STAFF REPORT

SUNCADIA PHASE 2 DIVISION 5 (LP-19-00001)

TO: Kittitas County Board of County Commissioners
FROM: Dusty Pilkington, Planner
RE: Suncadia Phase 2 Division 5 Preliminary Plat (LP-19-00001)
DATE: May 7th, 2019 [public hearing date]

A PORTION OF SECTIONS 18 AND 19, TWP. 20 N., RGE., 15 E., W.M.,  
KITITAS COUNTY, WASHINGTON

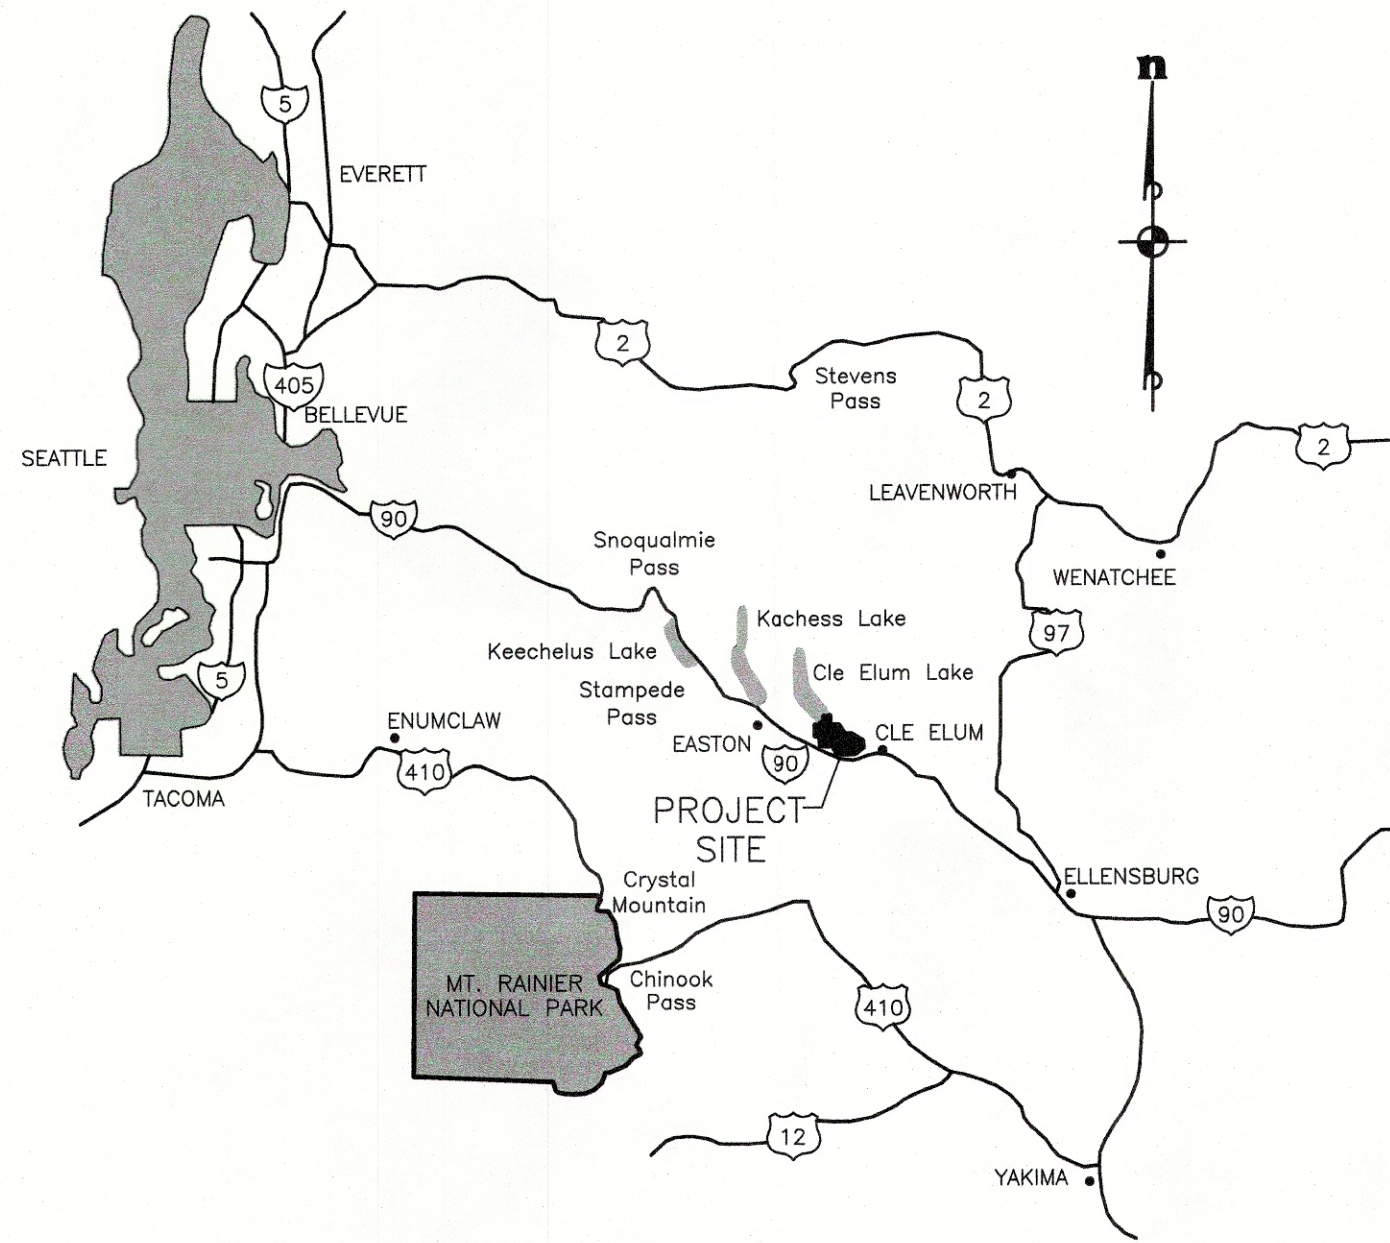
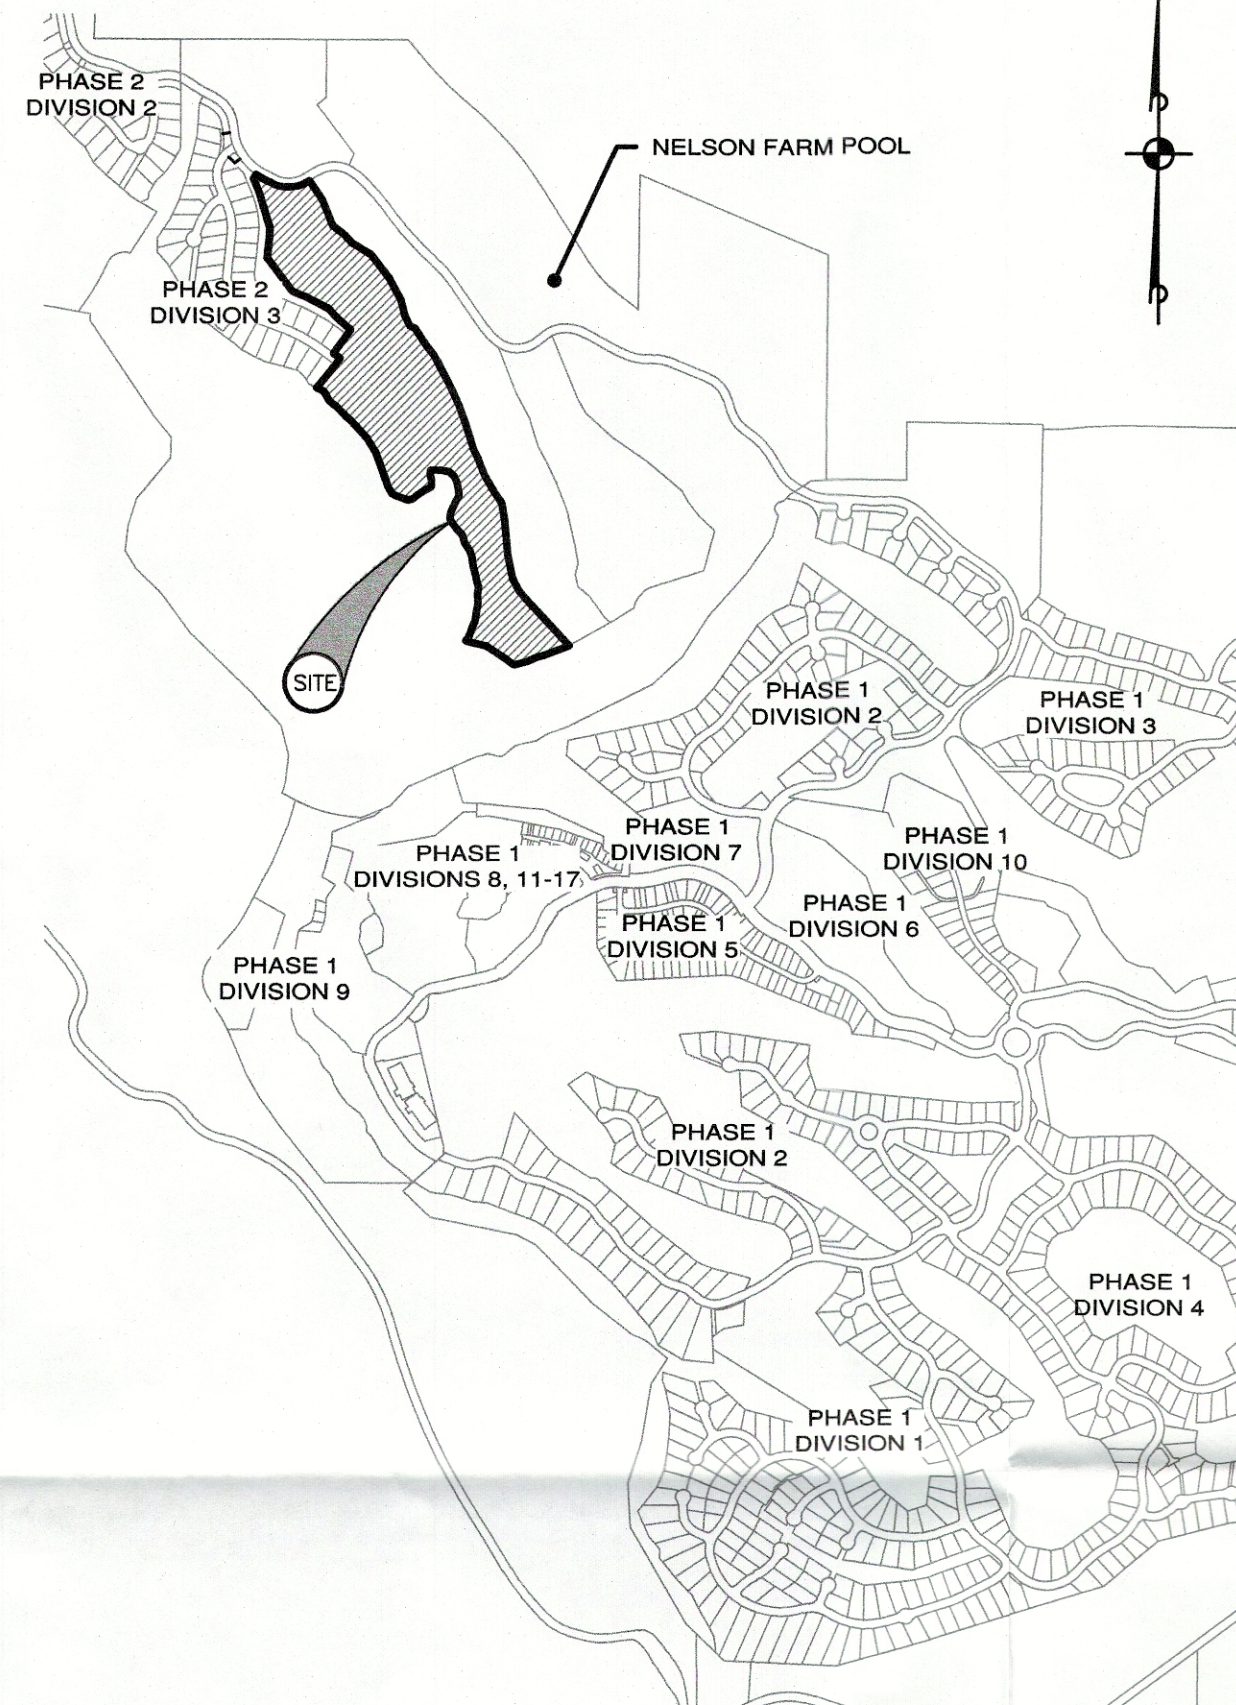
- 5) PW requires the following in regards to survey and planning:
- a. Sheets PP-1 through PP-5 shall be stamped by a licensed surveyor. Please see KCC 16.24.0210 for survey requirements.

Plotted: 1/23/2019 1:54 PM File: \\esmc\engr\ESM-1085\998\773\018\PP-plat\Plots\PP-04.dwg

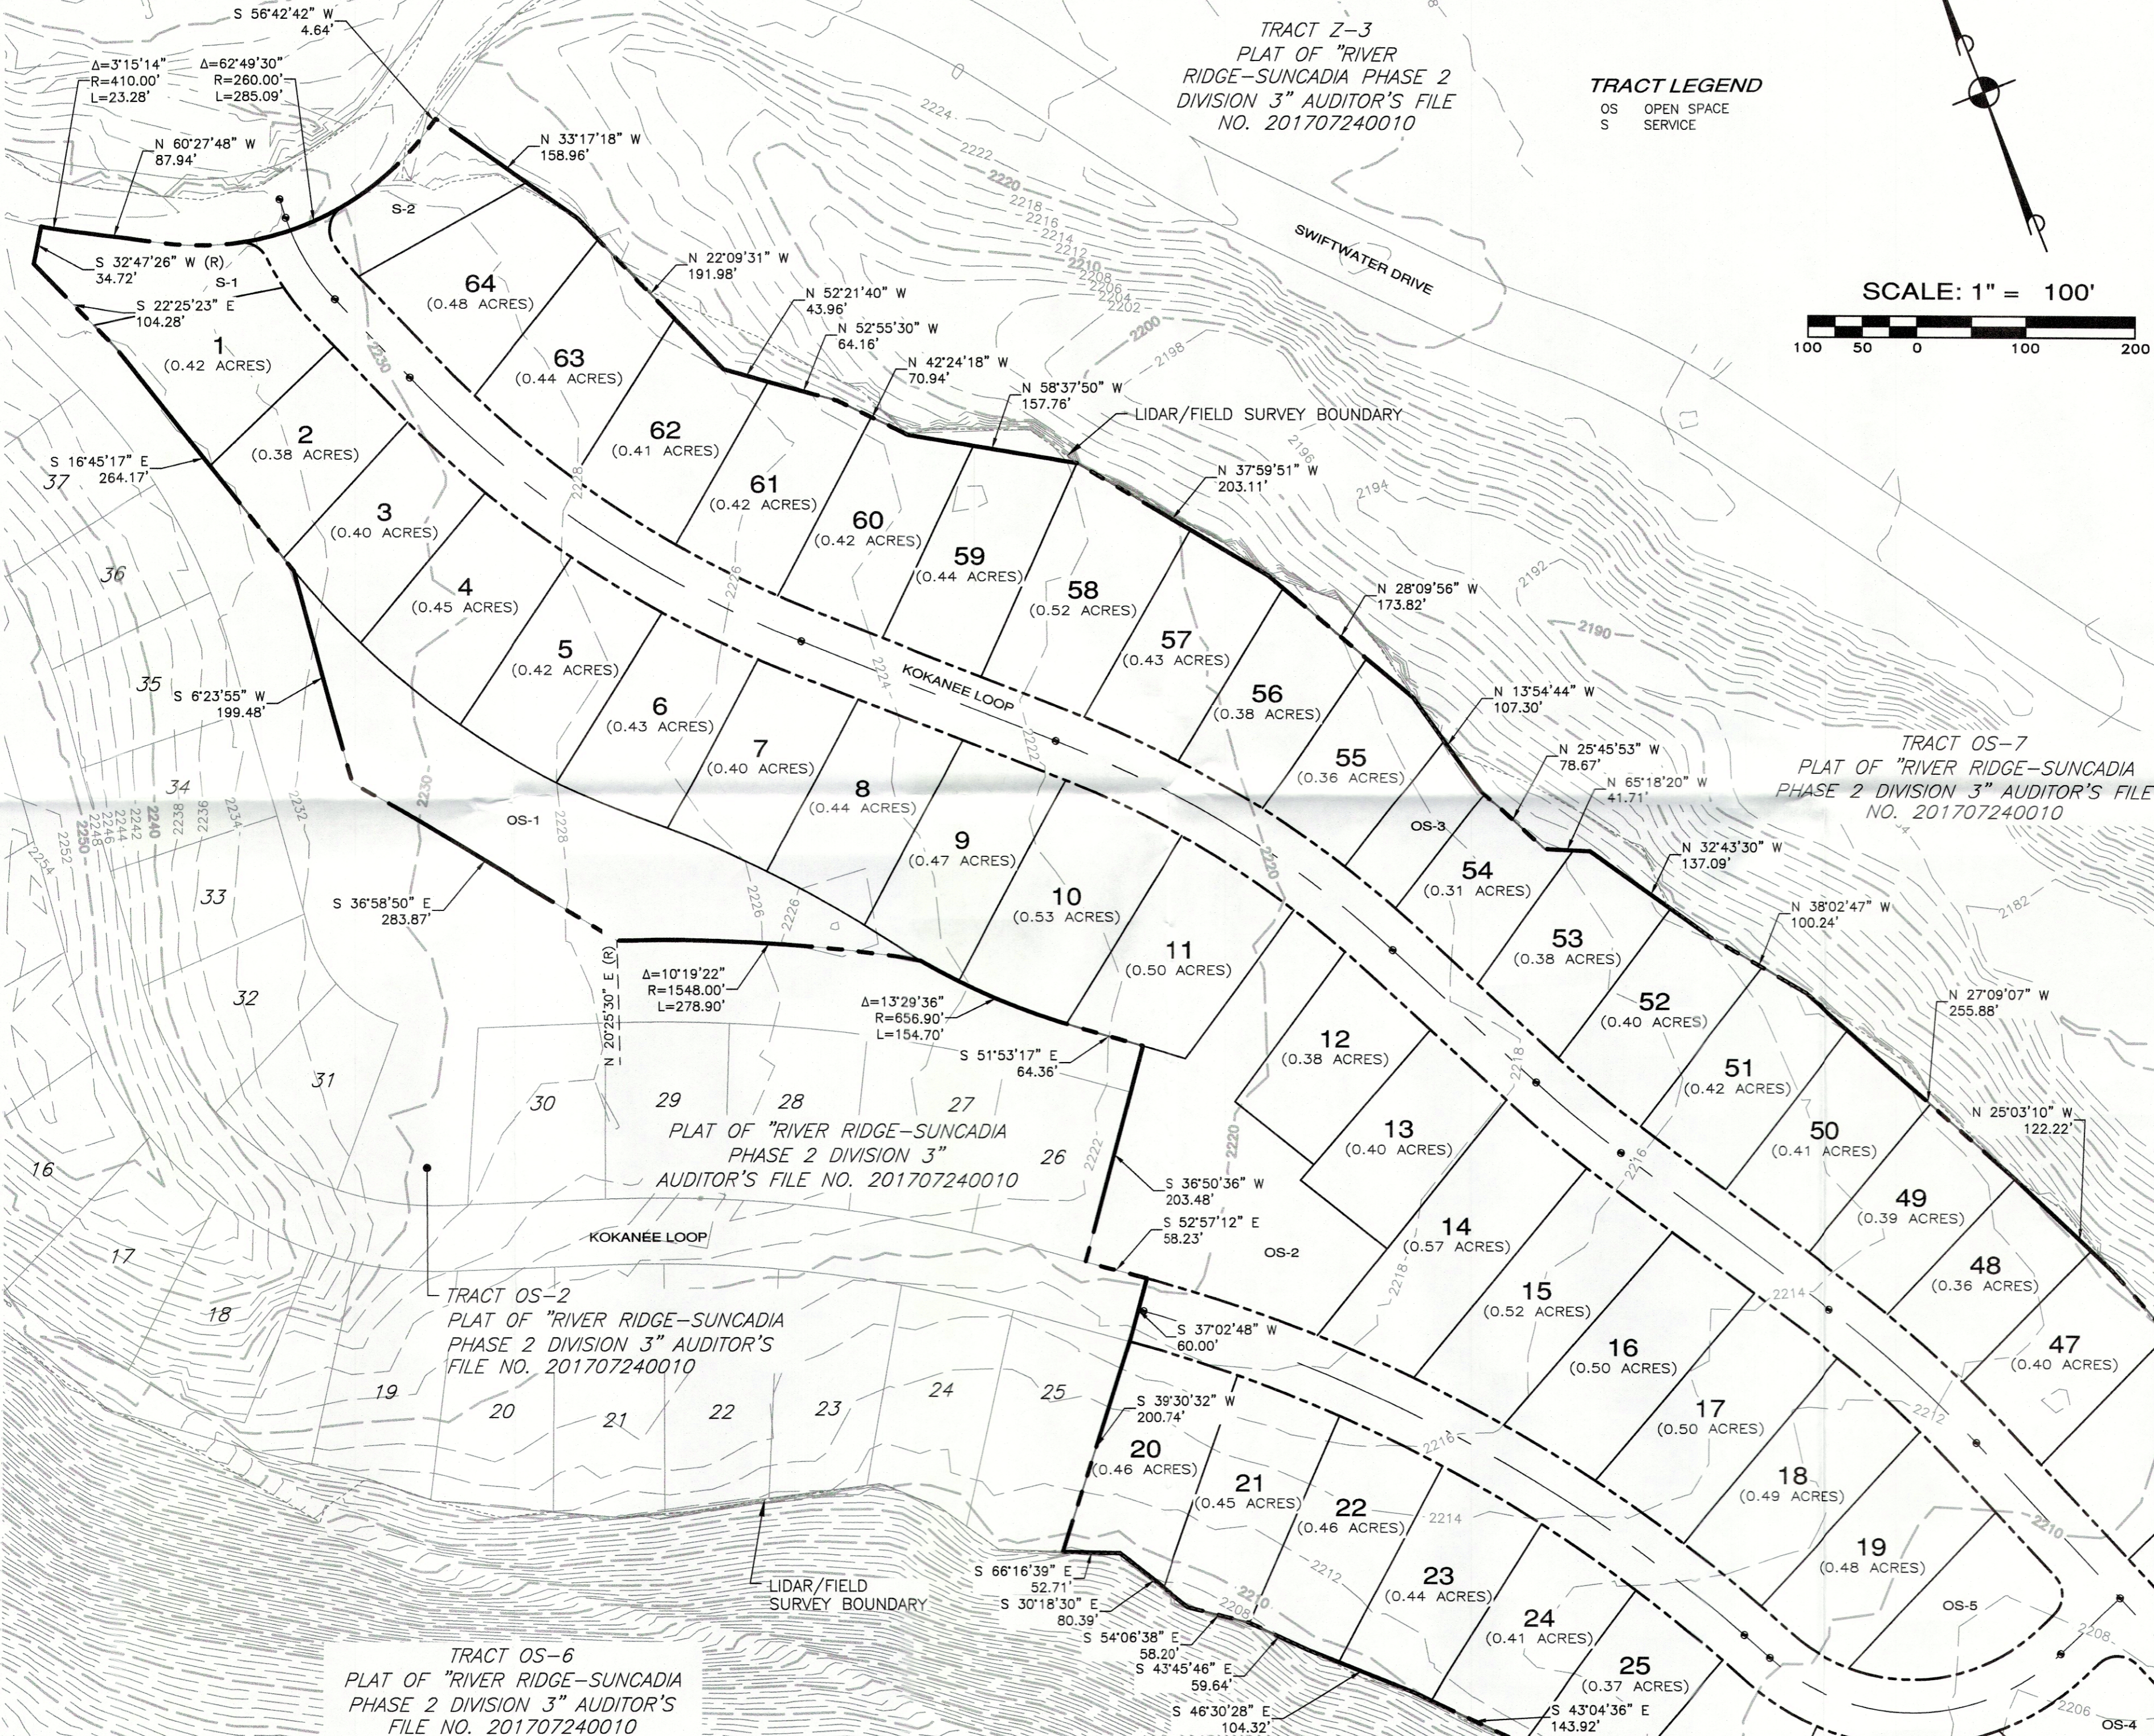
- b. The biofiltration swale depicted on lot S-4 appears to be situated immediately up-gradient of a steep slope area. Please affirm that no slope instability is anticipated as a result of the biofiltration area on lot OS-4 is also close to the top of slope. Please confirm that no bank instability is likely to result from the location of the dispersion areas.

- b. Kokanee Loop and Kokanee Circle should show the 60' width and identify if the intent is a dedicated right of way or an easement.
 - c. Timing of Improvements: Per the Suncadia 2009 Development Agreement section 5.3 Infrastructure, Surety Bonding or Other Assurances. Infrastructure identified by Trendwest in an approved Site Development Plan must be provided and available for use before the issuance of the first certificate of occupancy for Master Planned Resort Accommodation Units included within such plan. For purposes of final plat approval or issuance of building permits, infrastructure may be guaranteed through surety bonding or other financial assurance device acceptable to the County. The estimated costs of providing all such guaranteed Infrastructure shall be reviewed and approved by the County Public Works Director or designee. Surety bonding or other acceptable financial device provided to the County shall be in an amount equal to at least 110% of such estimated costs as determined by Trendwest's architects and engineers.

Staff Response: Staff agrees with Kittitas County Public Works requirements (Index #s 26, 27). The applicant will adhere to all applicable regulations as outlined in the Development Agreement.
